Application No: LU/85/22/PL
Site Address: 38-40 High Street Littlehampton BN17 5ED
Description of works: External alterations associated with the change of use of the upper floors to two flats (change of use sought under separate application for Prior Approval) consisting of installation of replacement dormer window to rear roof slope, installation of new ground floor access door to eastern side elevation; installation of 3 No new windows at first floor level to the western side elevation, installation of 1 No new window at second floor level to rear elevation, relocation of 4 No AC units from first floor western side elevation to the adjacent flat roof & installation of cycle storage and refuse and recycling storage within the rear curtilage. This application is in CIL Zone 4 (Zero Rated) as other development.

Thank you for your internet representation made on 2nd May 2022 which has been recorded as an objection with the comments as follows:

Proposed Ground Floor Plan 1:100

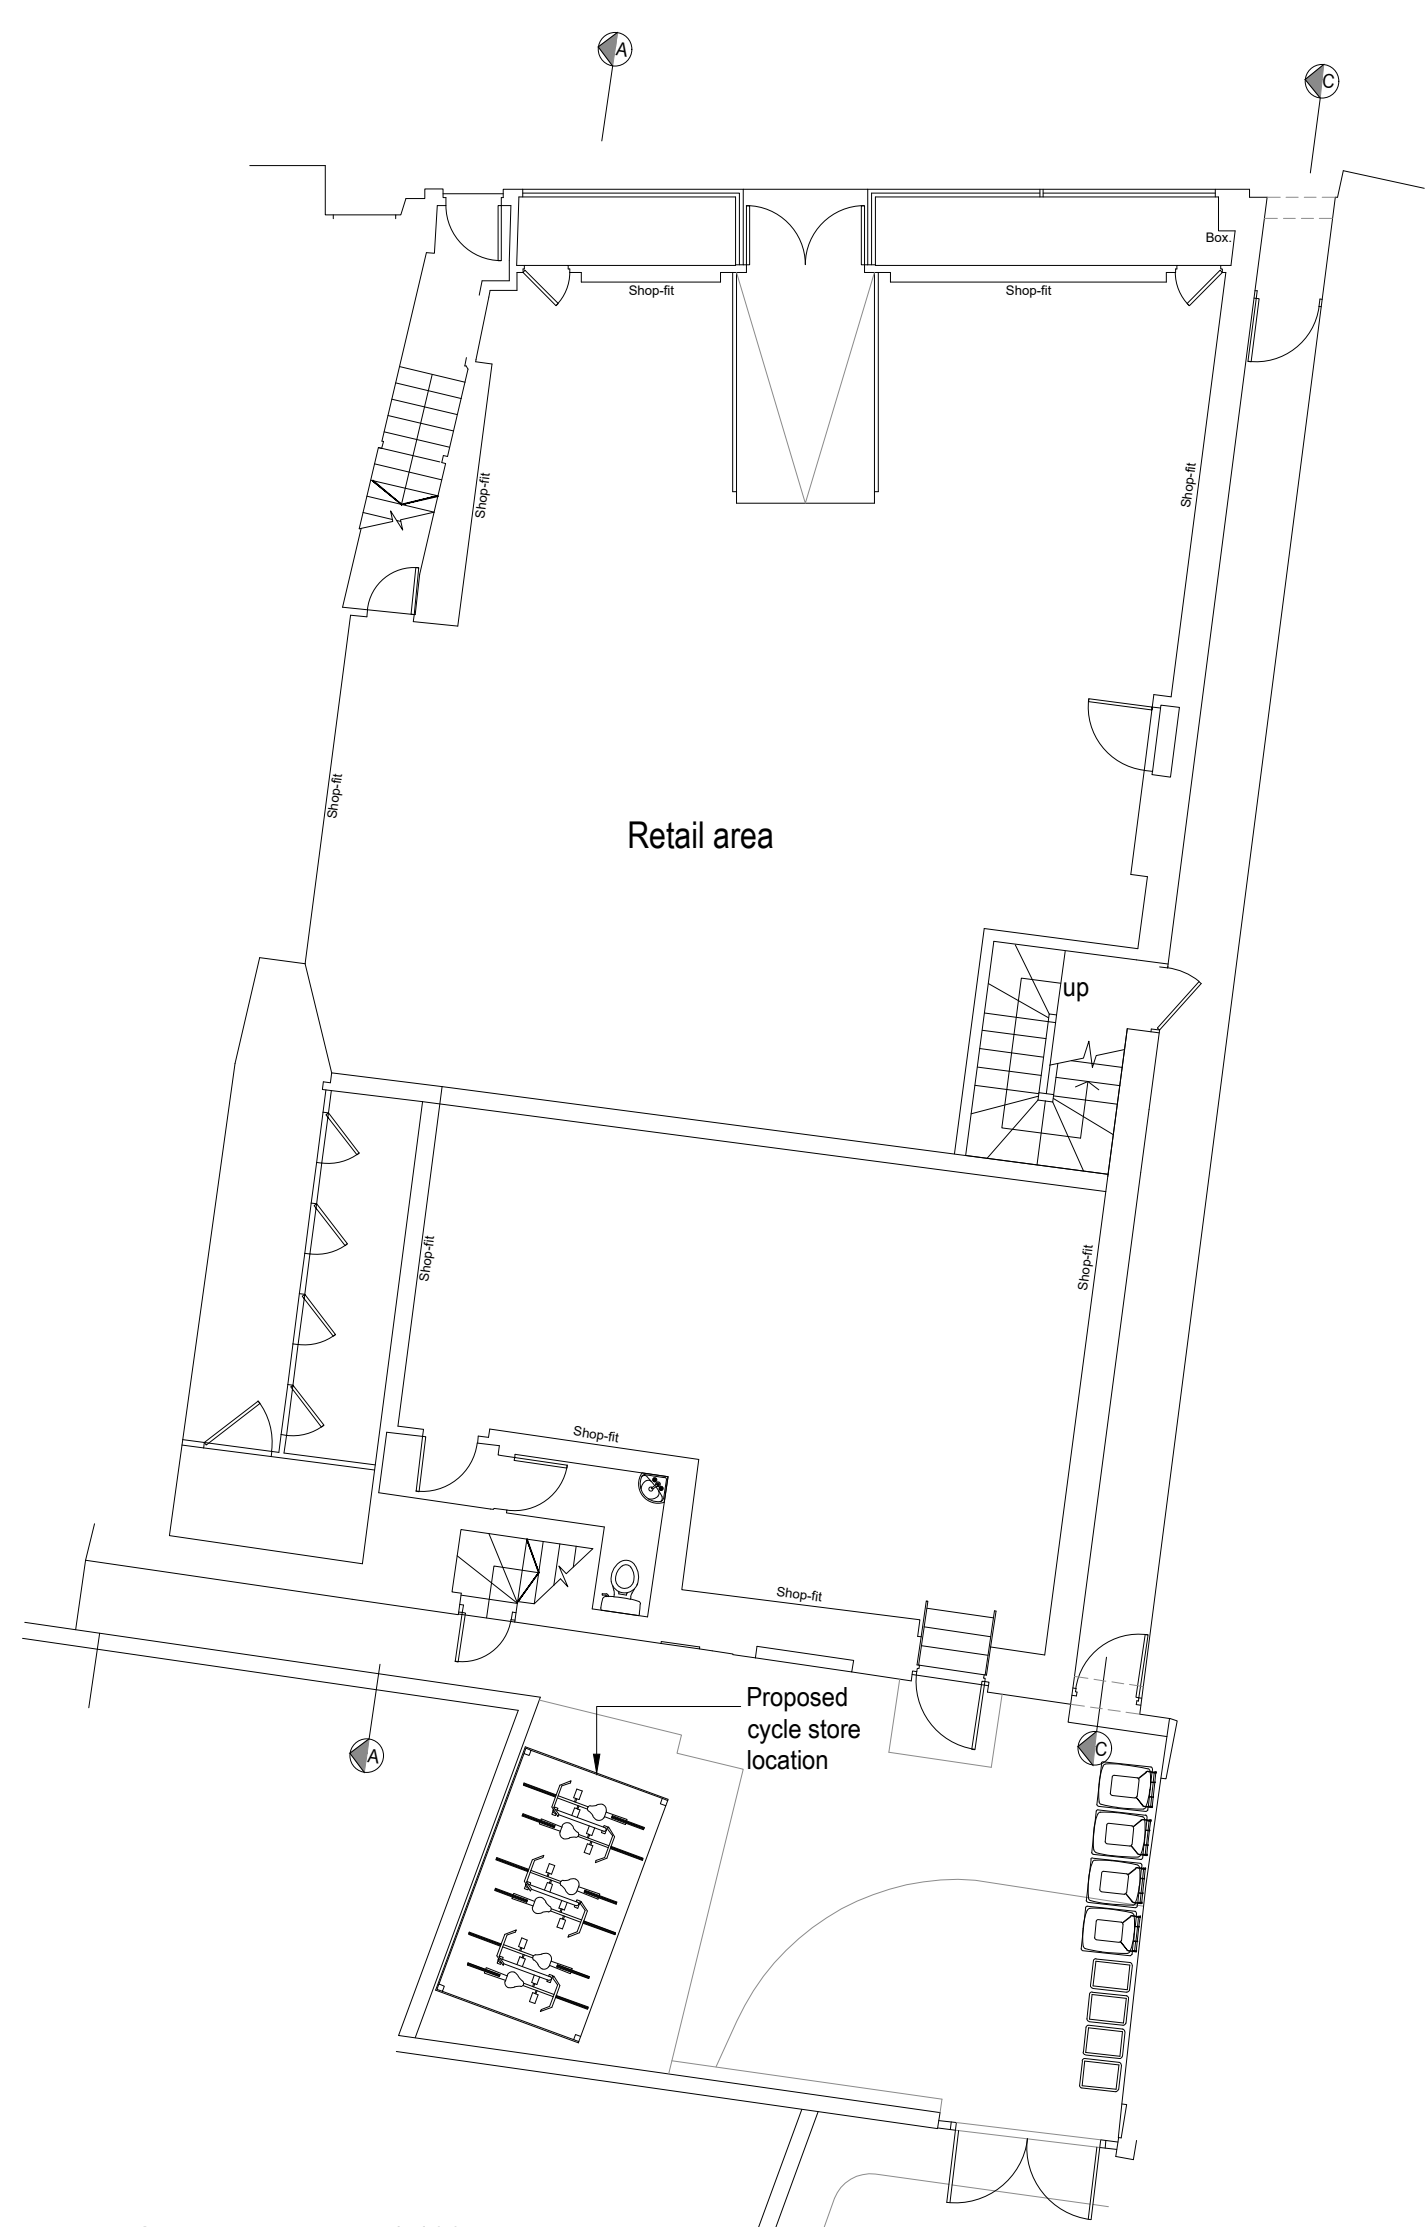
Having looked at the drawings I am concerned about the impact this will have on the existing retail unit

And the commercial viability being lost through the alterations suggested. The changes reduce the retail space by increasing the ground floor supporting spaces such as staff rooms, stock rooms which all though businesses need to operate are taking away a lot of the existing retail floor on this drawing. Littlehampton has few large retail sites and if it is to effectively have good regeneration then it must have a good mix of commercial sites to suit needs of a range of businesses. The beautiful new high Street paving will be worthless if the high Street is just lots of empty medium-sized units

Access might also be an issue as there appears to be no more rear access for goods which means businesses will be limited to bringing goods through the front of the store.
